Department of Transportation

September 30, 2020

SH 21B/Palmer Park Blvd.
El Paso County

RE: Wendy's Standalone Deviation 2020_EA18199

Figure 2

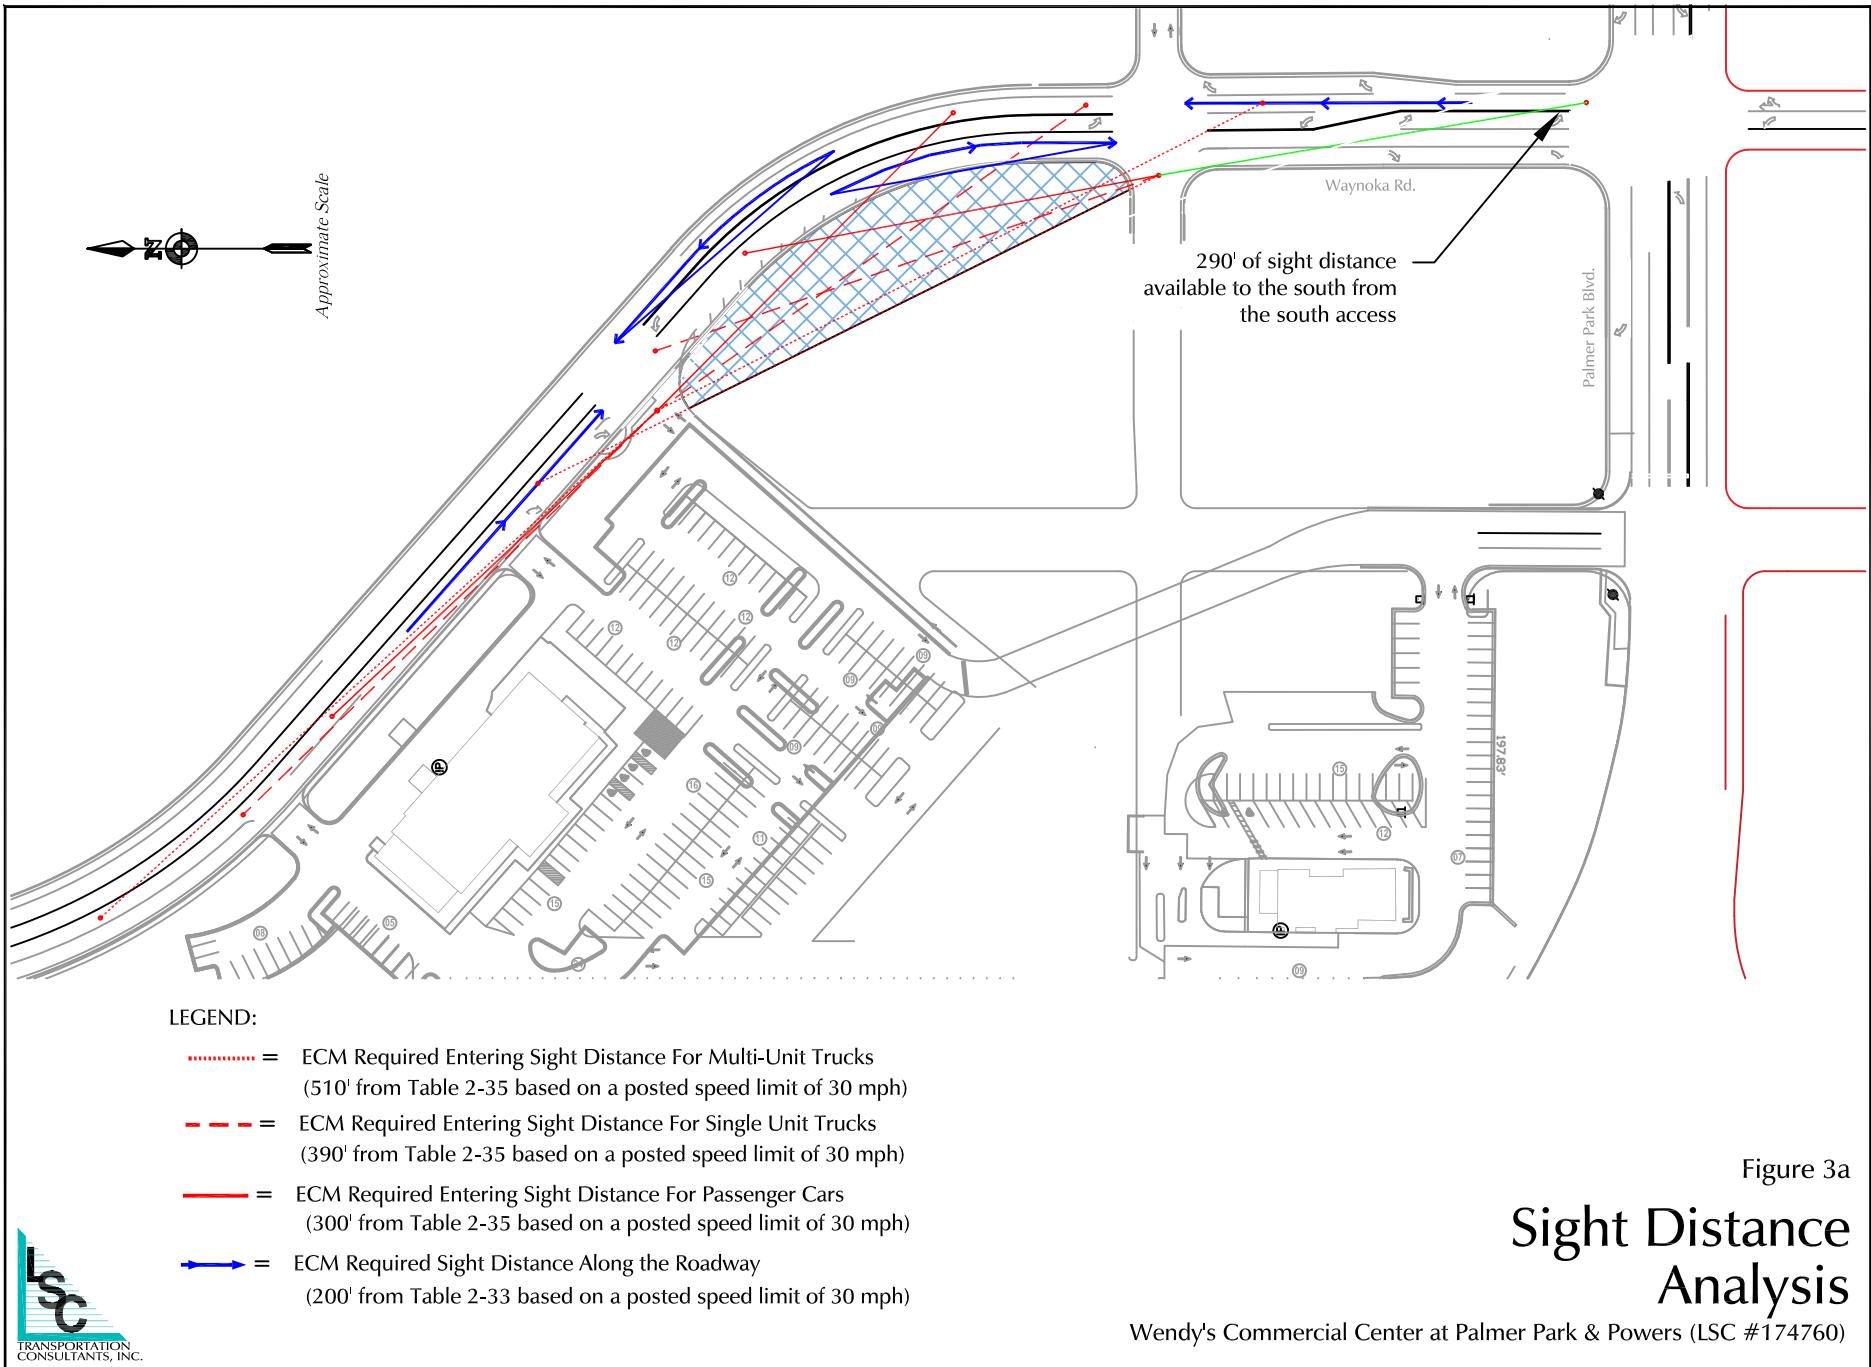
- CDOT Staff reviewed the Traffic Impst Study and the site plan is shown in Figure 2 dated July 2, 2020 and our commetnts are as follows;
 - a) An updated access permit will be required for the change in use as detailed in the State Highway Access Code, section 2, 2.6 for more that 20% increase of traffic volume to the site.

- b) The existing (access one) a full-movement signalized intersection is approximately 100-feet from the turn lane toughdown point of curvature on the northside of the roadway and will be required to be closed due to it's proximity with the functional area of the intersection. In situations where an interchange is not present we require this distance to be 300-feet away. It is recommended that this intersection be closed north and south side of the roadway with access to be gained from the new location of Waynoka Rd. Waynoka Rd. can deliver resonable access to the parcel.

- d) It is understood that Waynoka Rd. is to be realigned with the rear service drive road to approximately 200-feet to the west of the existing Waynoka ¾-movment intersection to allow for

a full-movement signalized intersection. It is also understood that this was predetermined via plat comments when initial development occurred. CDOT staff is ok with the realignment location and distance as determined by the State Highway Access Code, Sec. 2.13, Interchange Management Plans. The SH21B/Powers Blvd and Palmer Park Blvd. intersection is proposed to construct improvements from an intersection to an interchange at an undetermined time in the future.
